Our ref: Gregory Place Build-to-Rent (SSD-31179510)

Subject: Response to Submissions

ATTACHMENT 1 – KEY ISSUES

**Figure 3 Level 1 Landscaping**

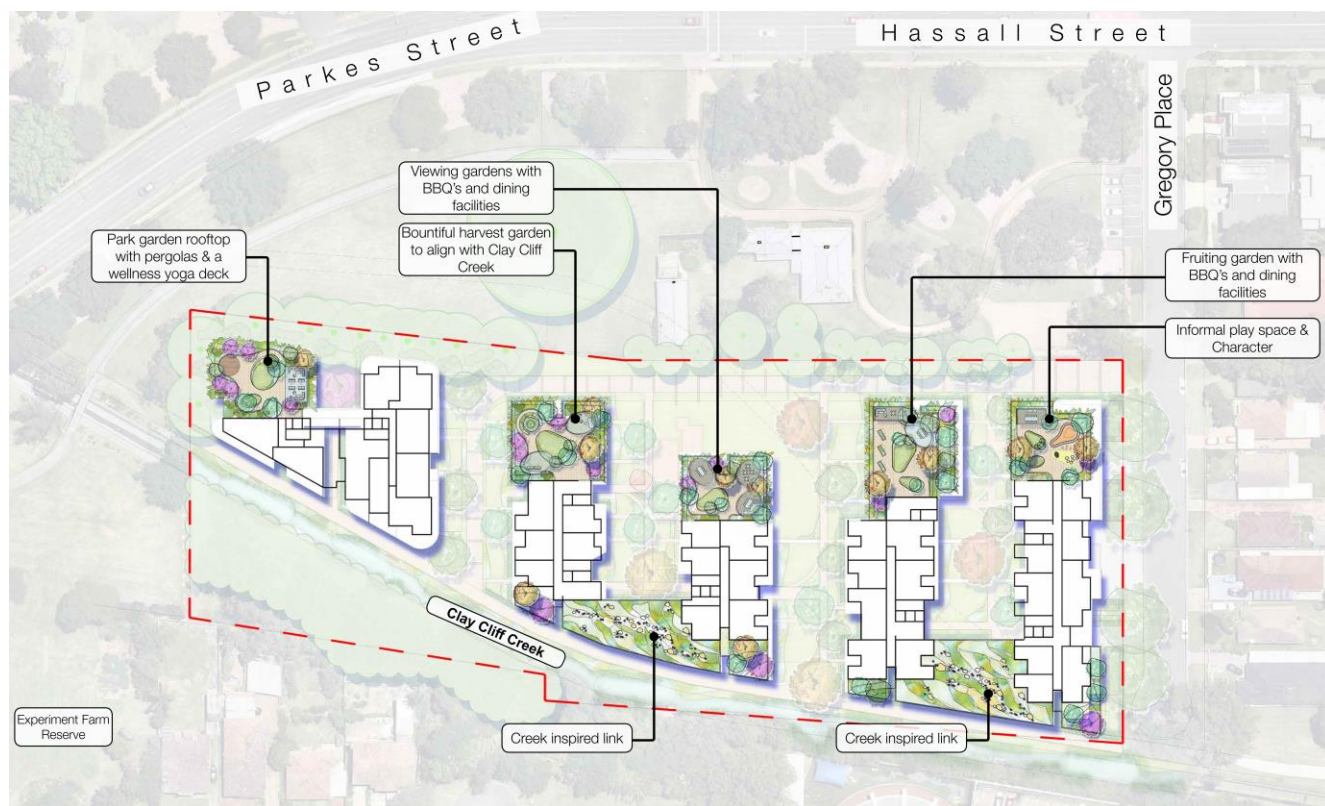
- The total landscaped area calculations within the architectural plans show passages, accessways, walkways, and roof terraces as "landscaped area". Landscaped area is defined as "*part of a site used for growing plants, grasses and trees, but does not include any building, structure or hard paved area*" under the Parramatta Local Environmental Plan 2011.

- These area should be included as open space and not landscaped areas. Updated architectural plans with accurate landscaped area calculations are required.

- There are inconsistencies between the total landscaped area calculations in the architectural plans (CD4007) and page 20 of the landscape plans.
- The architectural plans indicate skylights would be installed for sunlight and cross ventilation within the roof. The landscape plans indicate that the entirety of the roofs would include vegetation in the form of "green roofs". The Energy Efficiency & Ecologically Sustainable Design Report notes that a 500 kW PV solar system would also be installed on the roofs. Address how all three of these outcomes would be feasibly achieved and describe any required amendments to area calculations, solar access or cross ventilation.

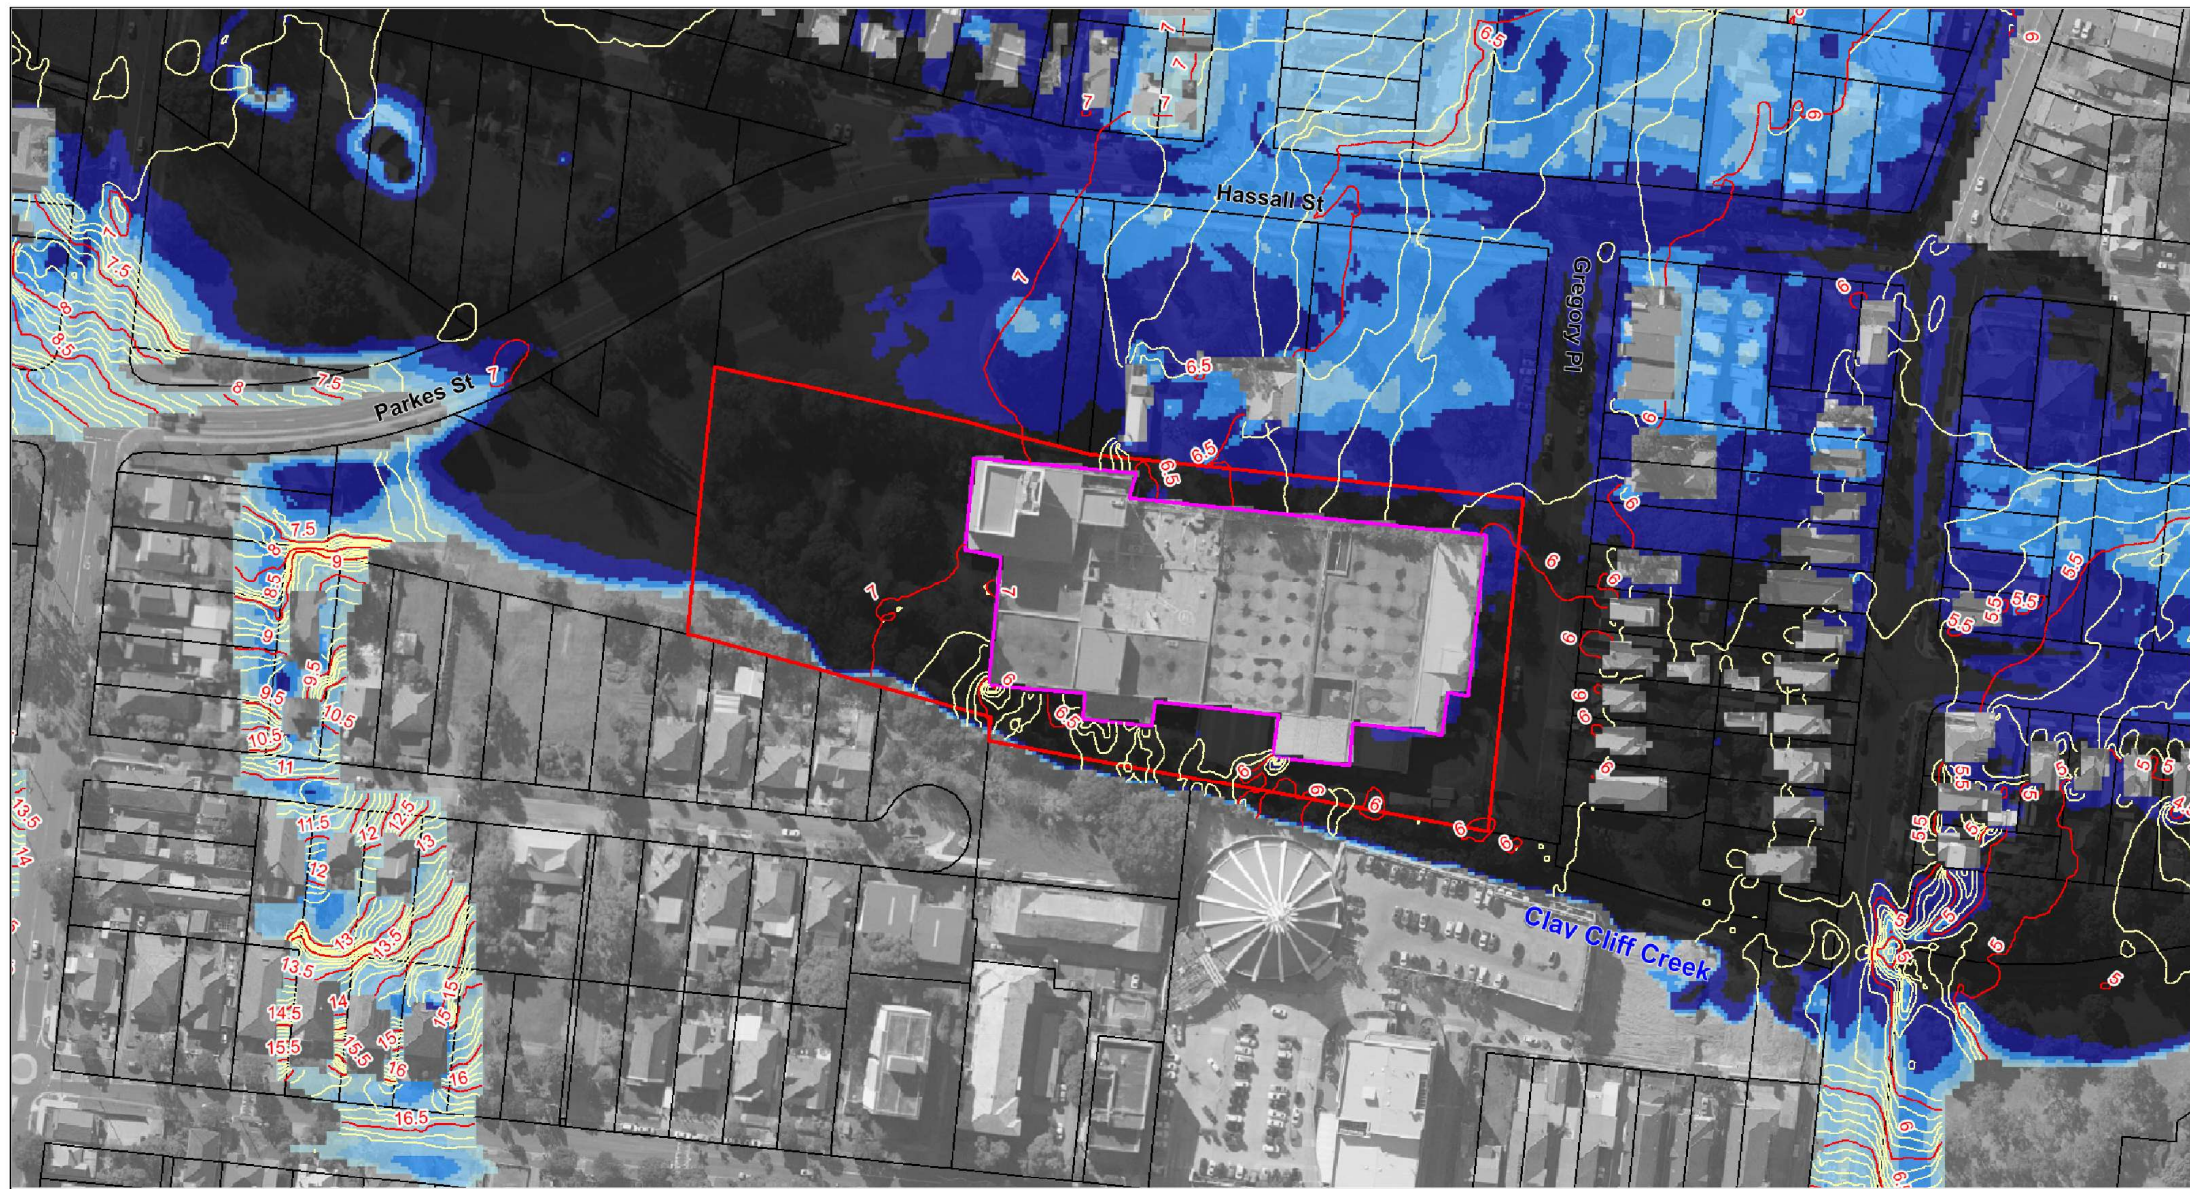
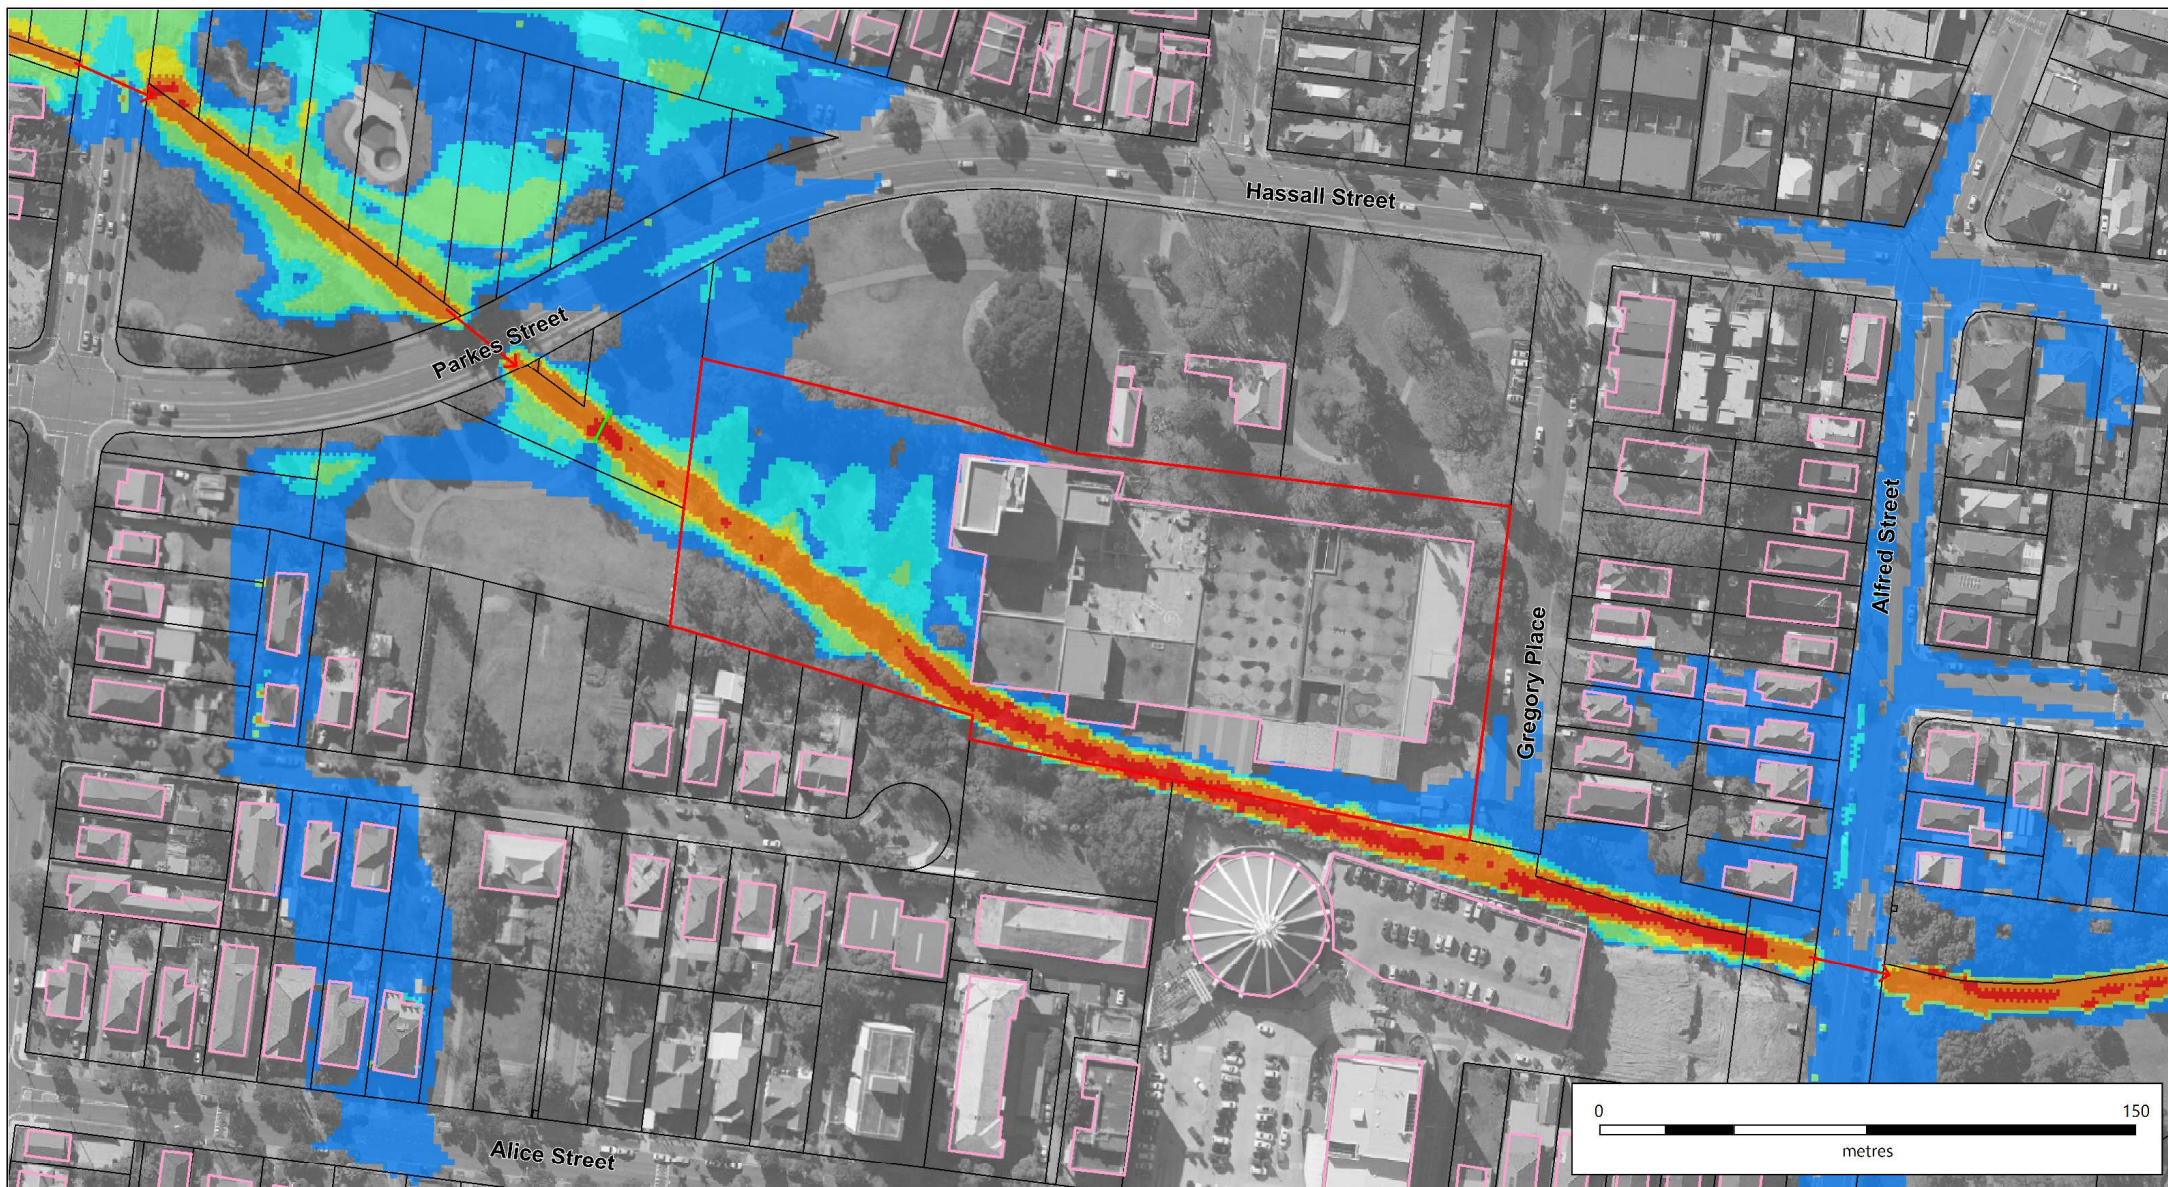
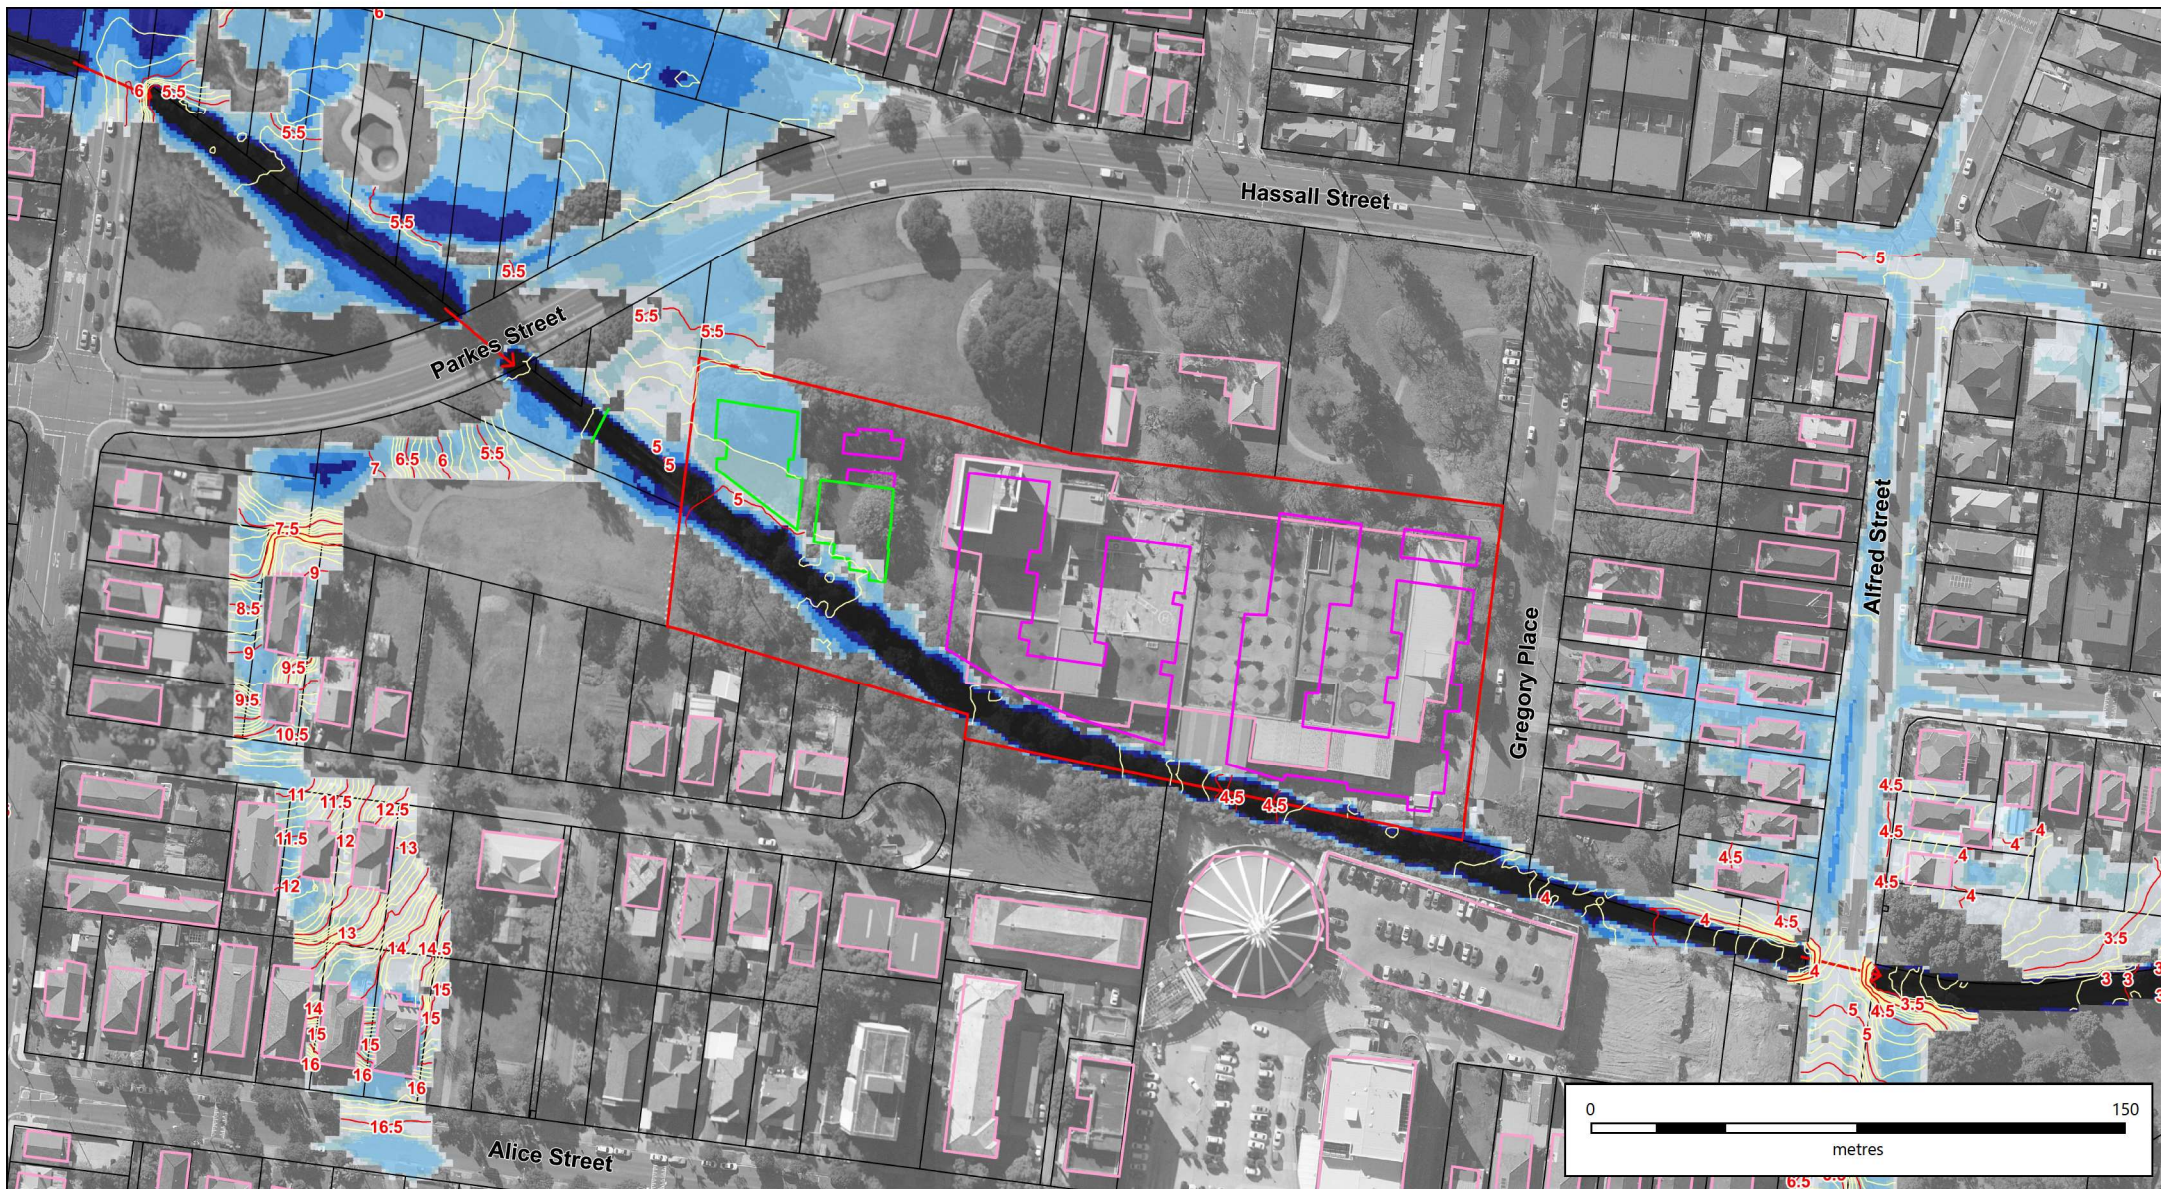
- There appears to be inconsistencies between the flood modelling provided in the flood report and council's adopted flood maps. The modelling must be updated to take into consideration council's adopted flood study levels. Any revised modelling should also address the site's classification as being within a 'High Flood Hazard Area' including consideration of the structural integrity of the proposed building within the identified hazard area. The revised modelling should also consider blockage factors, overland flows and climate change.

- Provide flood details for each individual stage of development. For example, how would a 1% AEP flood impact the development if only Stage 1 was completed, and no additional flood storage was present.
